Appeal Decision

Appeal Ref: APP/A2525/W/22/3310042

Churchills, West Street, Long Sutton, Spalding PE12 9BN

- The appeal is made under section 78 of the Town and Country Planning Act 1990 against a refusal to grant planning permission.
- The appeal is made by Mr K Bunn against the decision of South Holland District Council.
- The application Ref H11-0726-22, dated 20 July 2022, was refused by notice dated 19 October 2022.
- The development proposed is conversion of snooker room into 2 Bedrooms to be rented out to general public (no breakfast will be provided).

SITE PLAN

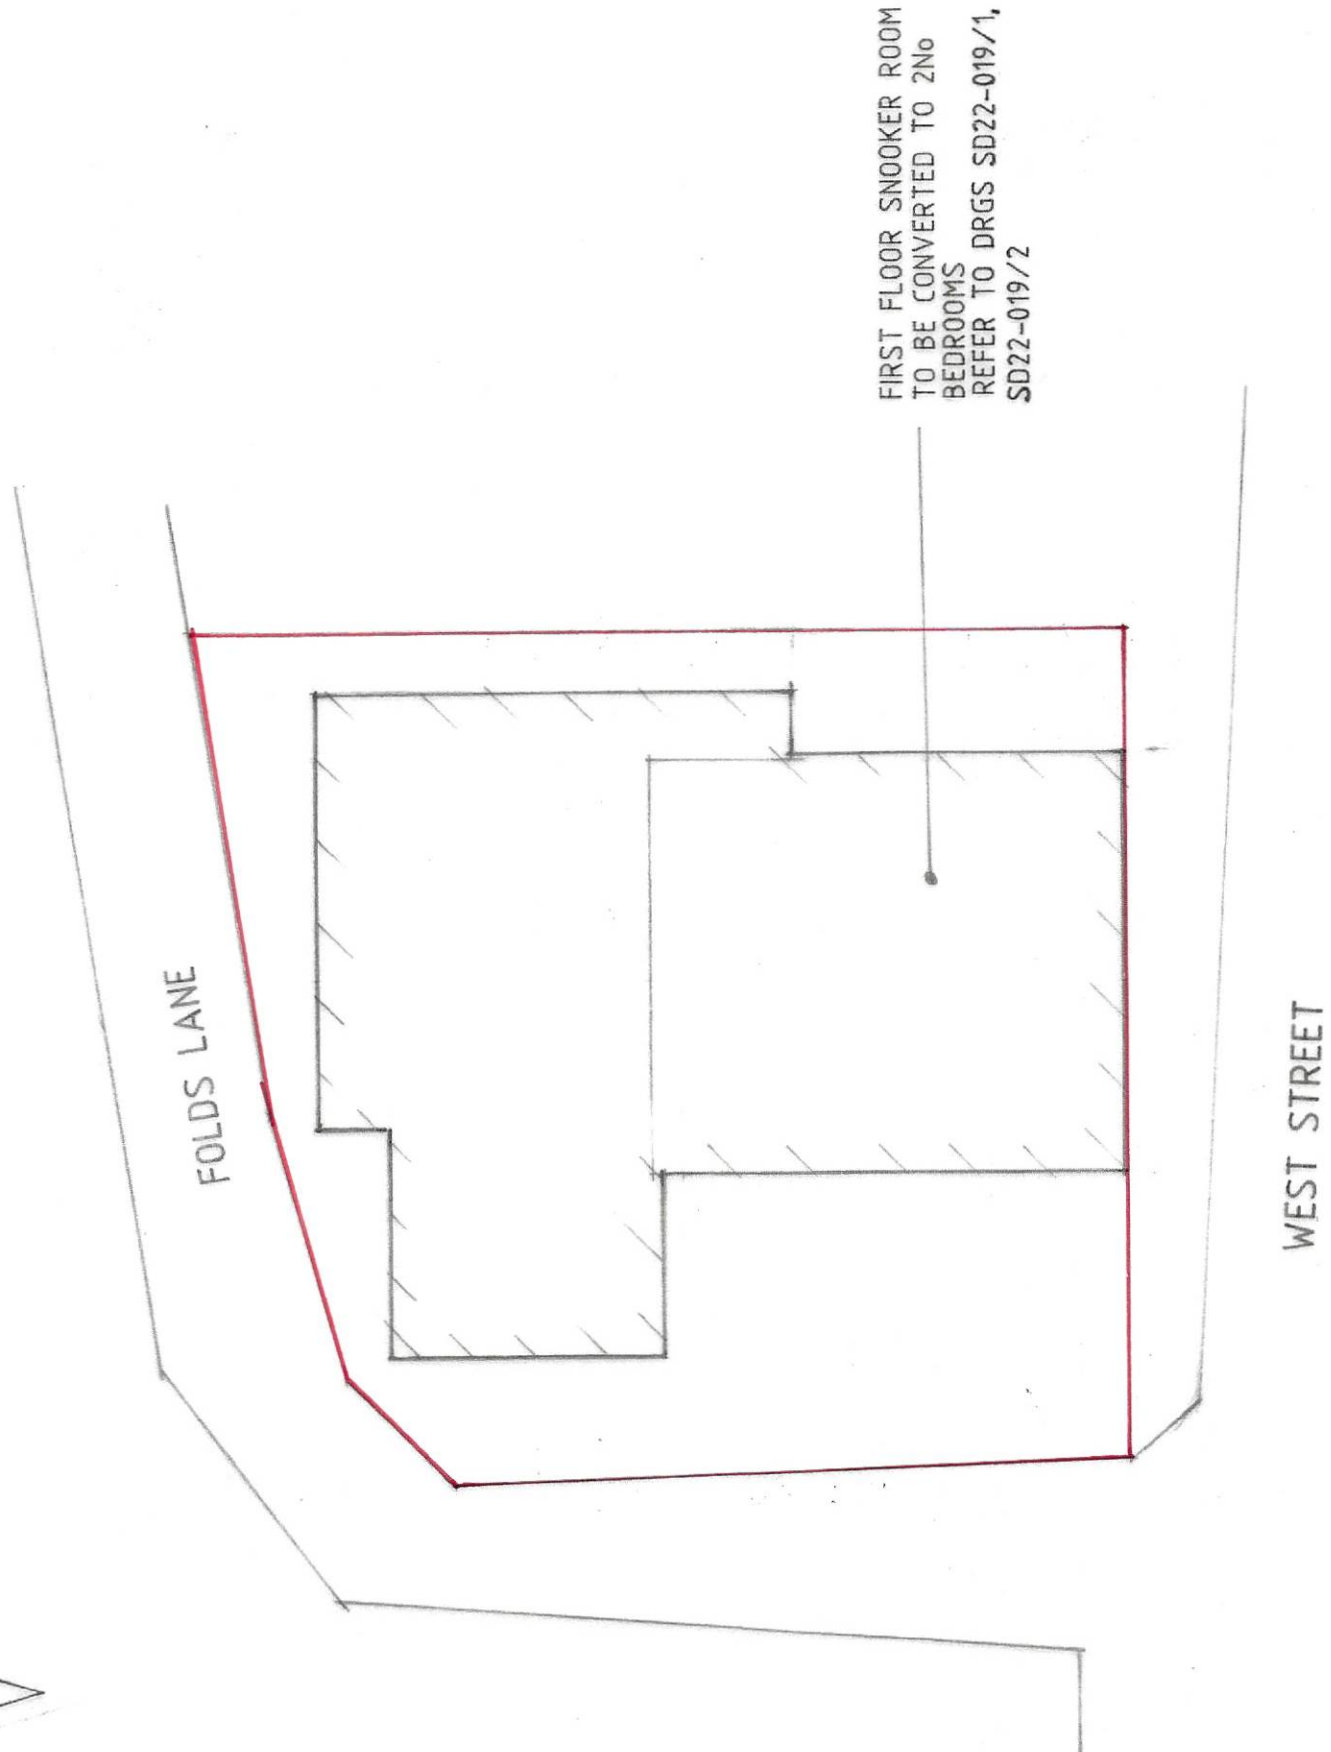
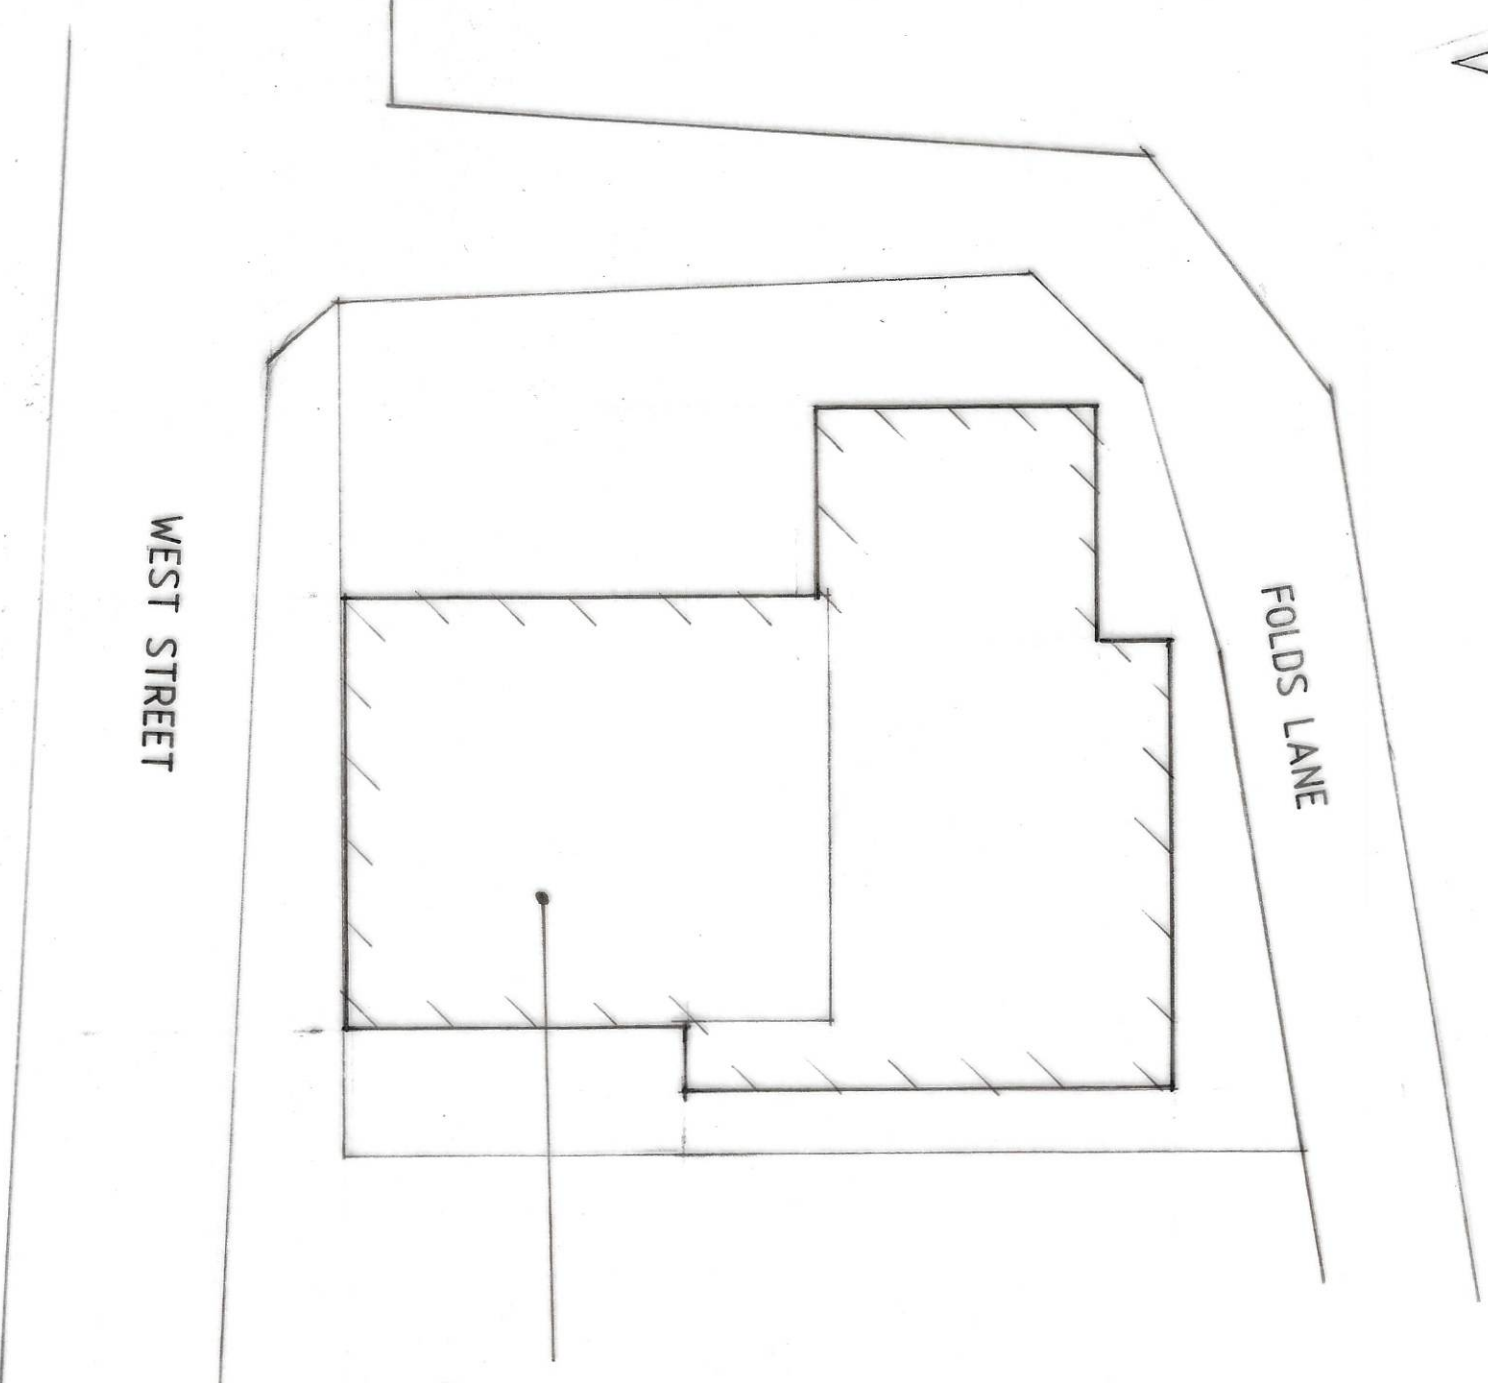
4. Policy 36 of the South East Lincolnshire Local Plan 2011-36 (2019) (LP) in summary, requires all new development, including changes of use, to provide parking in accordance with minimum standards unless a high quality-design can demonstrate that a lower standard of provision meets the overall aims of the policy. Furthermore, it states innovative solutions to vehicle parking provision including shared spaces, and the incorporation of measures such as car clubs will be supported. It also says, in summary, that to demonstrate compliance a transport assessment (TA) and associated travel plan (TP) should be submitted which is proportionate to the scale of the scheme.
5. The proposal does not include the provision of any off street car parking spaces, whereas applying the Council's minimum parking standards, the

- proposal would be required to provide two off street parking spaces. This is not contested and the application is not supported by a TA or TP.
6. I note the comments that there are two public car parks within an extremely short distance to Churchill's so it is highly unlikely that any cars relating to an overnight stay would park on the roadside. However, there is no detailed information relating to whether these car parks would be accessible overnight or if any measures would be put in place to ensure the occupants of the proposed development would use them. Furthermore, there is also no analysis of on street parking in the area which allows me to understand whether or not the parking demand generated by the scheme could be reasonably met on street without compromising highway safety in the area.

7. I also acknowledge the comments that off street parking provision could be secured at another location nearby through an agreement of an appropriate planning obligation. However, the details of any such obligation are not before me and based on the evidence I cannot be satisfied such an approach would overcome the direct conflict with Policy 36 of the LP I have identified above.

9. Overall, therefore, based on the limited evidence before me, I must take a precautionary approach and find that due to the lack of appropriate off street parking provision, without clear substantive evidence to the contrary, there is a risk the scheme would compromise highway safety in the area. The proposed development therefore conflicts with the aims of Policies 2, 3 and 36 of the LP, which, among other things, seek to ensure new development is served by appropriate parking provision and does not compromise highway safety in the area.
